Application for a Non-Material Amendment Following a Grant of Planning Permission

Changing of bifold door at the rear elevation to a smaller door and a window

21/02500/HOU

21/02500/HOU

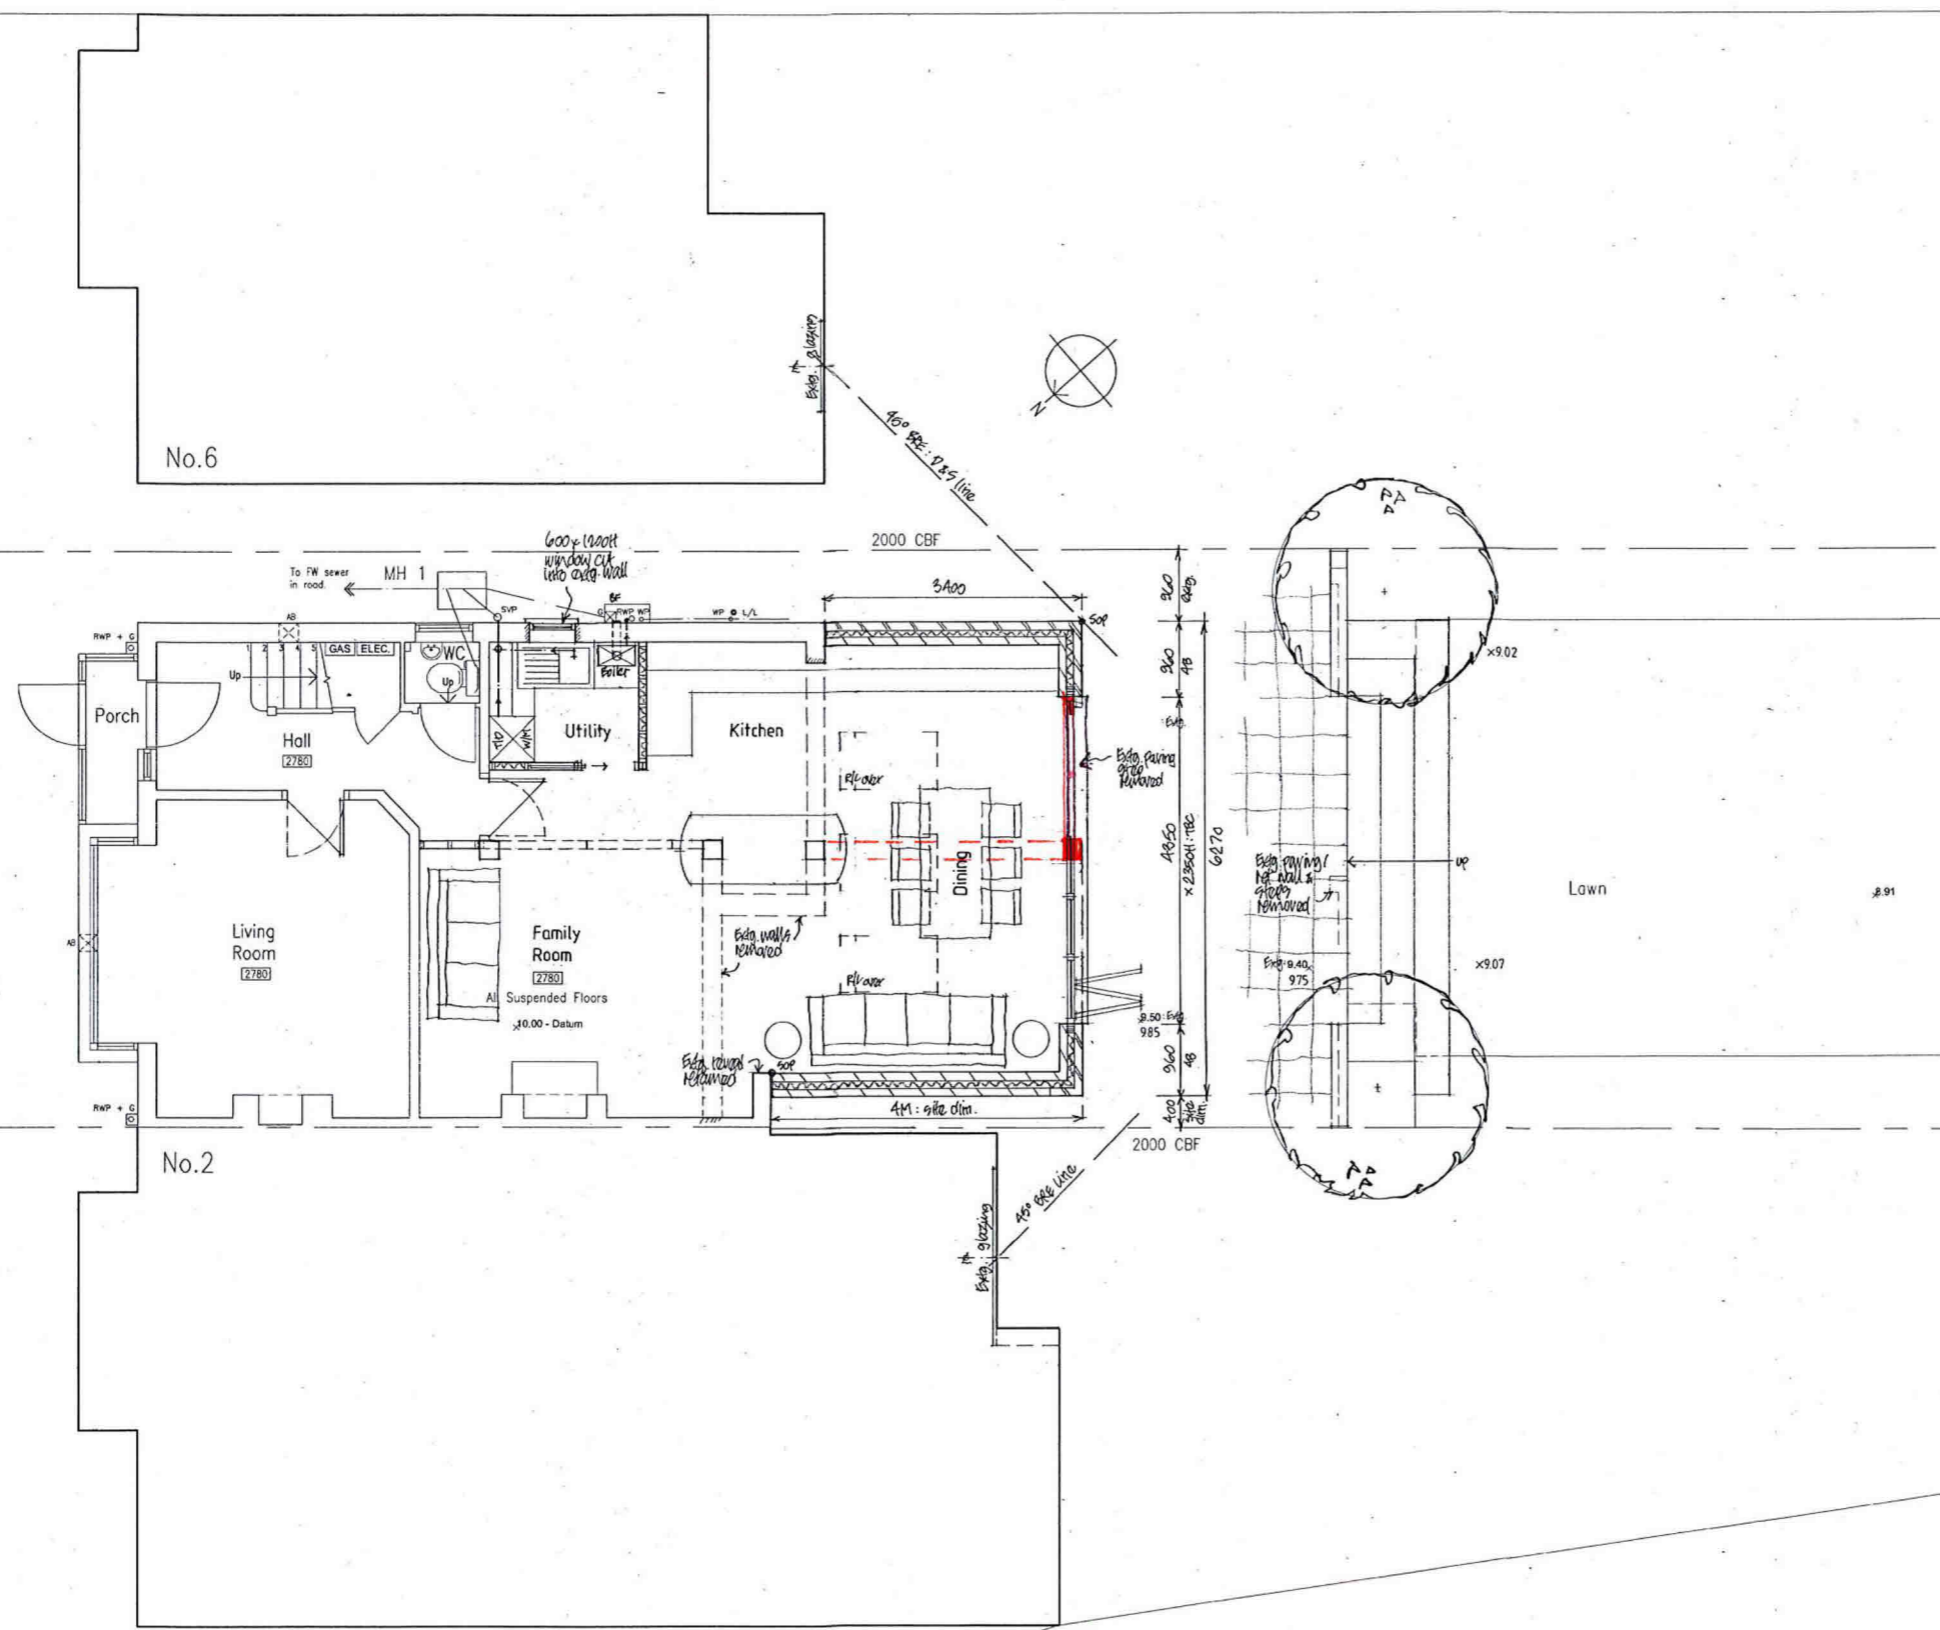
Change of bifold doors for a smaller door and a window at the rear elevation

Changes to the Kitchen layout

Plan - K146/04
Elevation - K146/06

Plan - K146/04 REV A
Elevation - K146/06 REV A
